Date: 14 September 2021

APPLICATION BY HIGHWAYS ENGLAND FOR AN ORDER GRANTING DEVELOPMENT CONSENT FOR THE A47 NORTH TUDDENHAM TO EASTON PROJECT

Environment Agency response to the Applicant's comments on the Environment Agency's Relevant Representation.

Figure 11-27 Floodwater displaced for the 100 year event (35% climate change) at Oak Farm

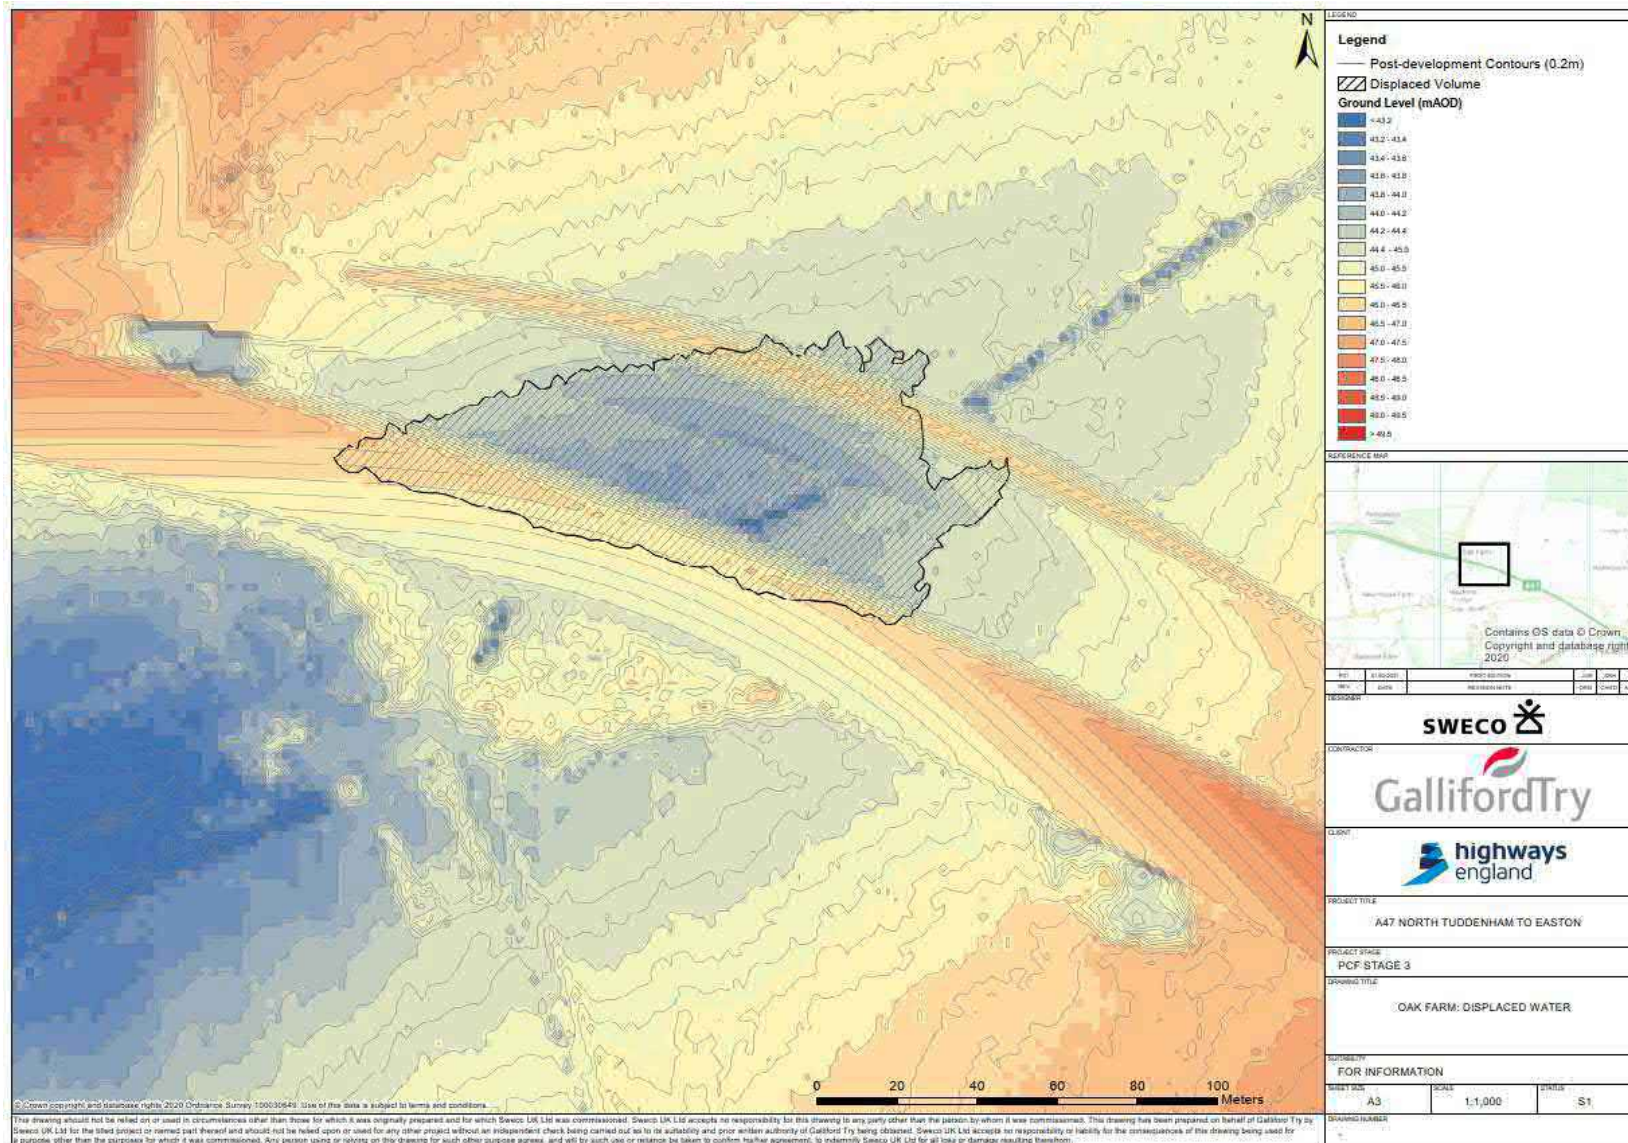
RR-066.31	6.7 Paragraph 7.3.1 of the FRA notes that there will be a small displacement of water on the Hockering watercourse, calculated to be 27m ³ . The paragraph states: "Due to the poor quality of LiDAR within this area and the fact that cross-sections are mainly based on interpolation, an uncertainty allowance of 20% has been included in the estimate". As stated at ES paragraph 13.9.36, we agree that no compensatory storage would be required for a loss in floodplain storage of 27m ³ . However, the	Further evidence will be provided to support the proposed design and to confirm the requirement for flood compensation storage. The ExA will be kept informed of outcome of this exercise during the DCO Examination process, and the Applicant expects to be in a position to issue an update or further information at Deadline 3. The outcome will also be record in the Statement of Common Ground with the Environment	We confirm that we are satisfied with this approach, and look forward to reviewing the further evidence.

Reference	Environment Agency Relevant Representation Comment	Highways England Response	Further Environment Agency Response at Deadline 2
	<p>Applicant should confirm that the 20% uncertainty allowance is a sufficient worst case scenario, and that there is no risk that a detailed topographic survey would change the amount of water displaced sufficiently to result in a compensatory storage scheme becoming required.</p>	<p>Agency. If required, appropriate updates will be made to the DCO application documents and submitted to the ExA.</p>	
RR-066.32	<p>6.8 In respect of surface water and ecology, paragraph 13.8.28 of the ES considers the potential impact of the River Tud crossing on the watercourse. Although shading is considered in respect of its potential effects on channel stability, structural damage and increasing sediment, the potential impact of the new 30m wide bridge deck on Water Framework Directive (WFD) Biological quality elements does not appear to have been assessed.</p>	<p>Open areas and areas of dense shading occur along the River Tud at a catchment scale and this provides the river with a greater degree of biodiversity than if all areas along the Tud were open. ES Appendix 8.4 Appendix 8.4 – River Tud Corridor Aquatic Invertebrate Survey (APP-099) states <i>“It is considered that any proposed works in and around the River Tud will have little impact on the invertebrate species recorded as long as mitigatory measures are taken to maintain river low rates and prevent possible sedimentation build up during works that may effect surface run-off or disturb the integrity of the river’s bankside.”</i> Shading from the proposed crossing will therefore have no effect on the invertebrate assemblage associated with the River Tud. In addition, the length of the River Tud area at the point of the crossing is shaded by trees.</p> <p>The Applicant is working with the Environment Agency to provide further assessment information on the macrophyte cover and marginal vegetation associated</p>	<p>As highlighted in our representations, it is our view that further assessment on the effects of shading on the River Tud as a result of the proposed bridge crossing is required.</p> <p>We welcome the further assessments being undertaken by the Applicant as described here and in respect of RR-066.34, and look forward to reviewing the outputs and subsequent proposals for mitigation. However, at this point we would wish to highlight that we would not consider the effects of shading from tree cover to be directly comparable to those caused by a bridge structure.</p>
